From: Peter Goodyear [REDACTED]
Sent: 07 December 2022 07:57
To: Sunnica Energy Farm [REDACTED]
Cc: [REDACTED]
Subject: Planning Inspectorate Reference EN010106 Registered party 20030564 Fordham (Cambs) Walking Group, Sunnica Energy Farm,

I am writing in advance of tomorrow's Issue Specific Hearing, to provide an update for item 6b Permissive Paths ISH3 Thursday 8 December 2022.

Please find attached your drawing number 60589004_ES_DAS_004 Rev 0 upon which I have overlaid in green sections within the DCO (P2-P8) that I feel warrant scoping, and a short section outside the DCO (P1) linking to East Fen Road Isleham. Whilst the latter section is outside the DCO, I understand the land is in the same ownership as adjoining land where you are having discussions.

Drawing Number 60589004_ES_DAS_004	Rev 0
--	-----------------

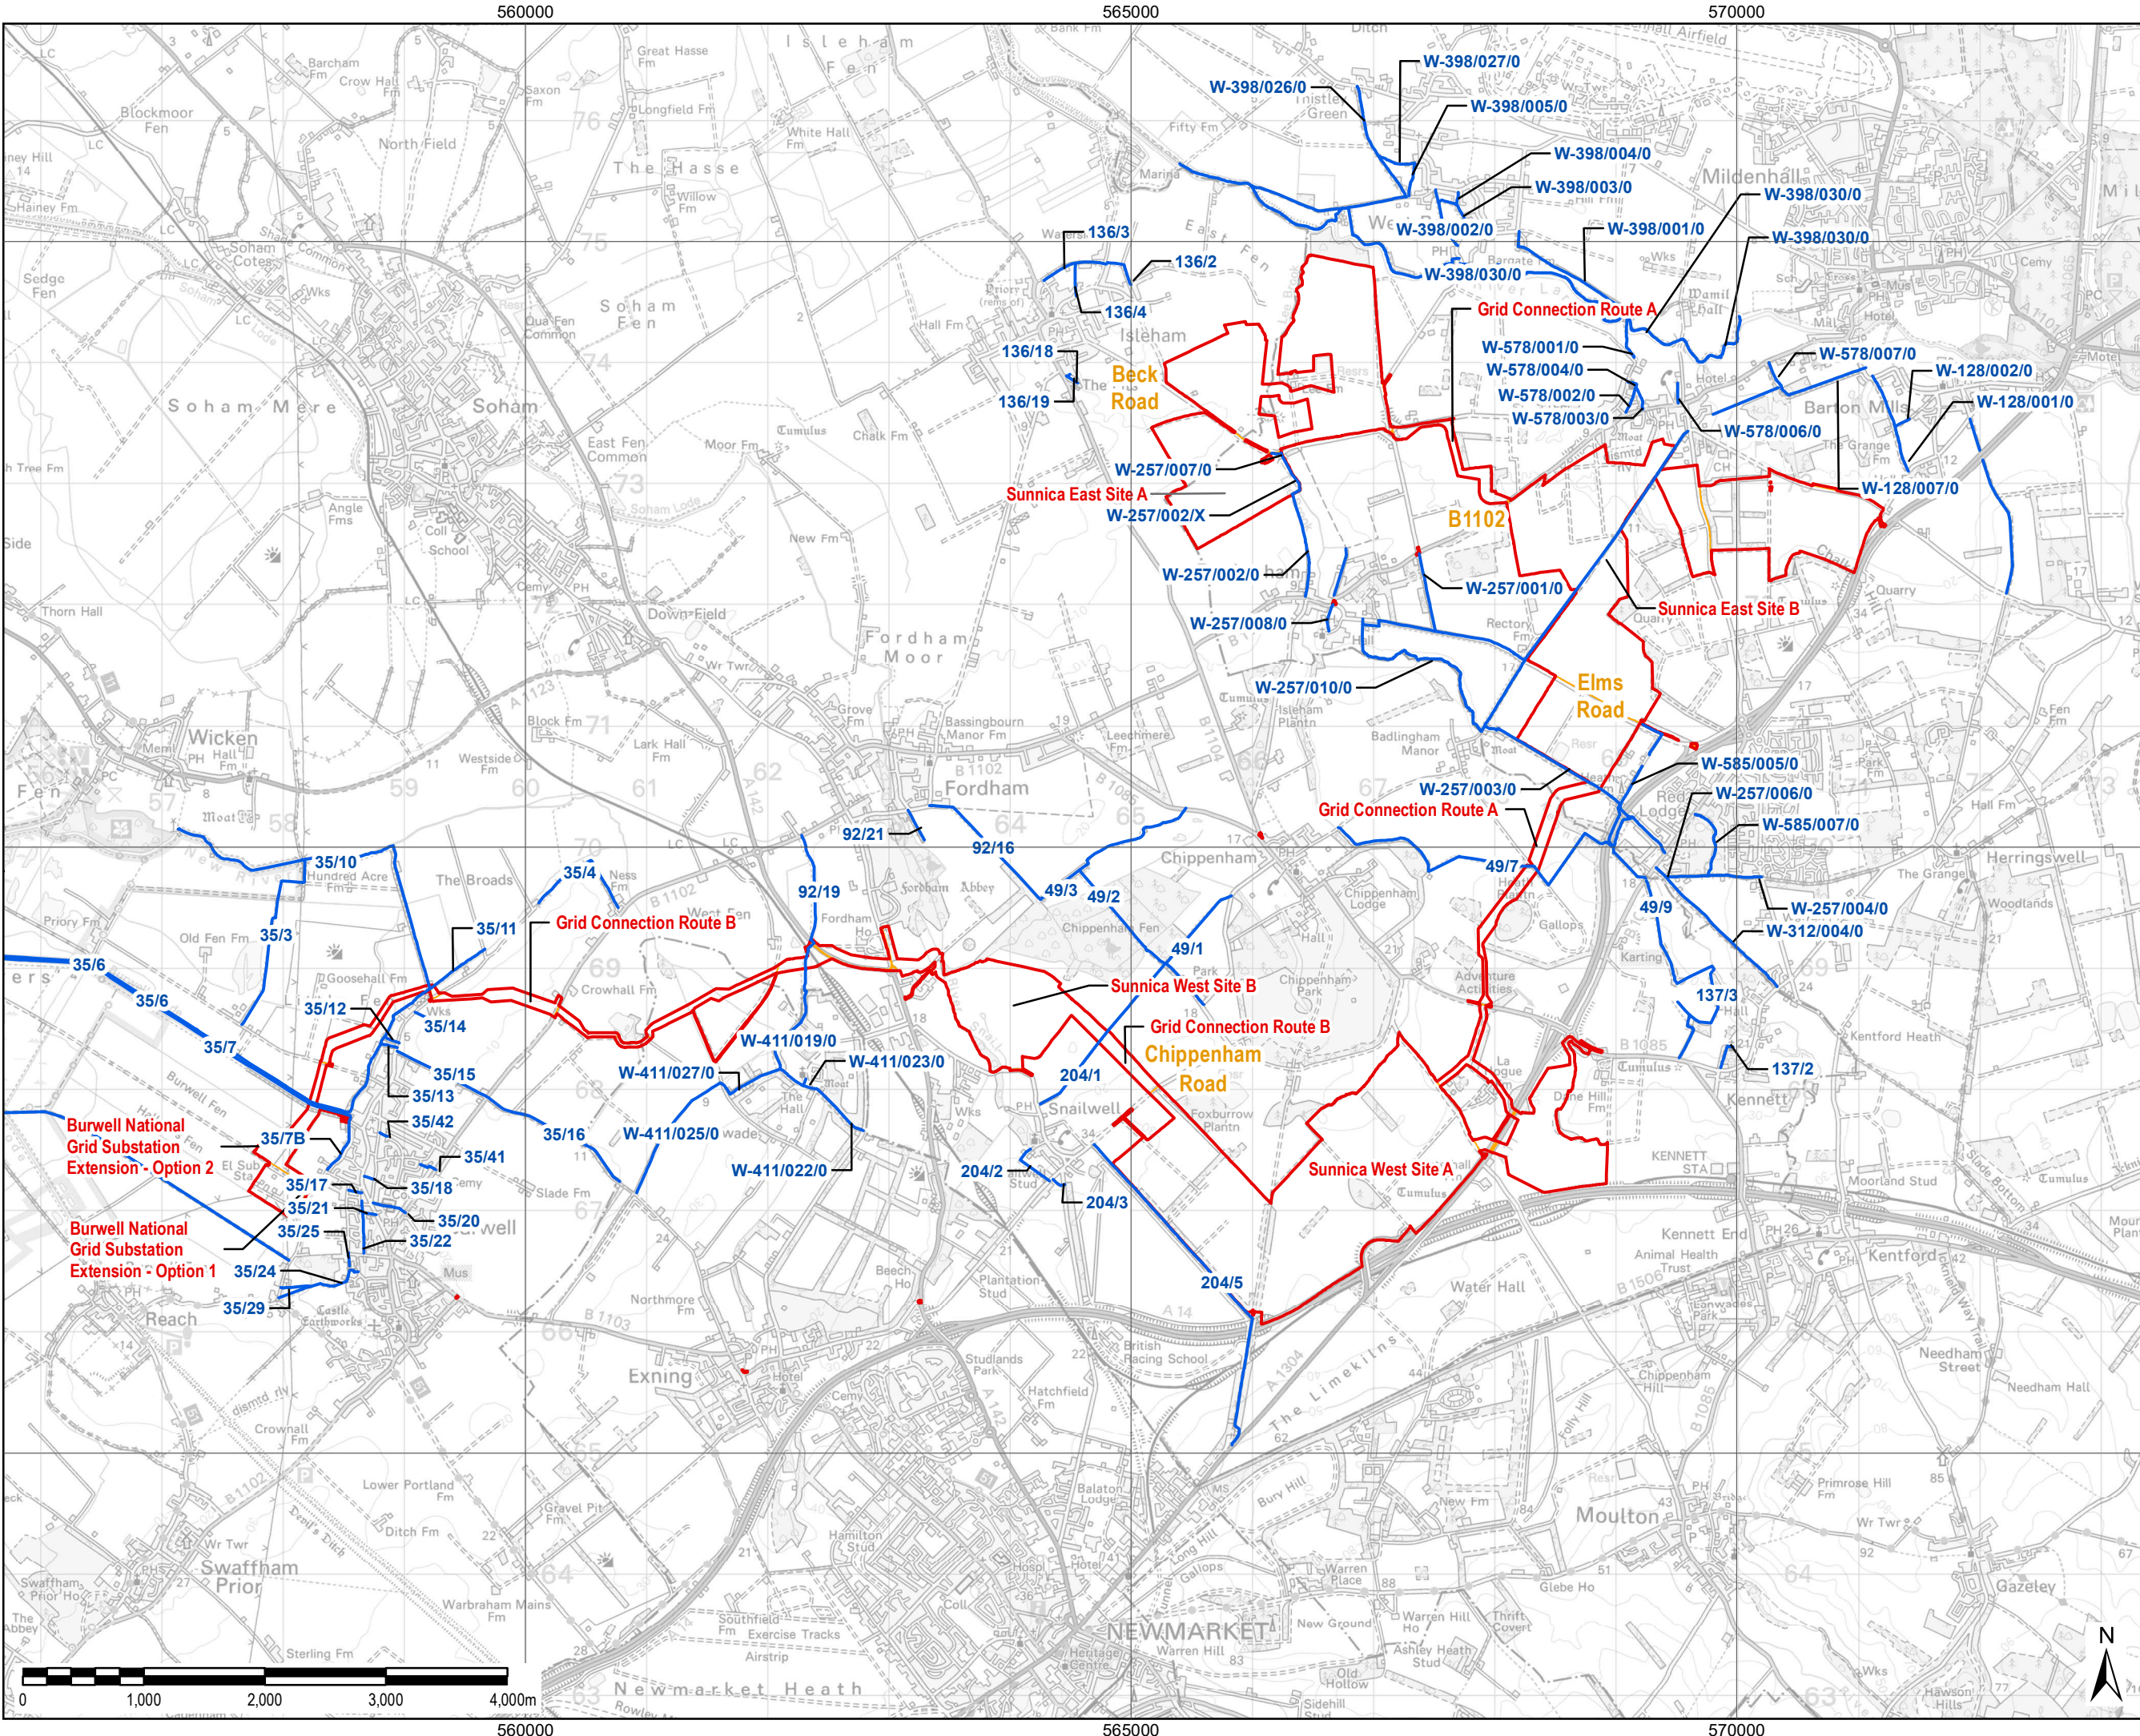
On your PROW map, the roads and settlements are greyed out, and the permissive routes are not shown on drawing 60589004_ES_LSP_004 Rev 0. This means it is extremely difficult to extrapolate how the network works and in places fails. It is possible that I have missed something in the volume of submitted material and I’d be grateful if you could point that out if that is the case. I have done my own mapping showing a lattice of existing and potentially beneficial new permissive routes, but I am unable to share this with the inquiry because my OS licence is a private one.
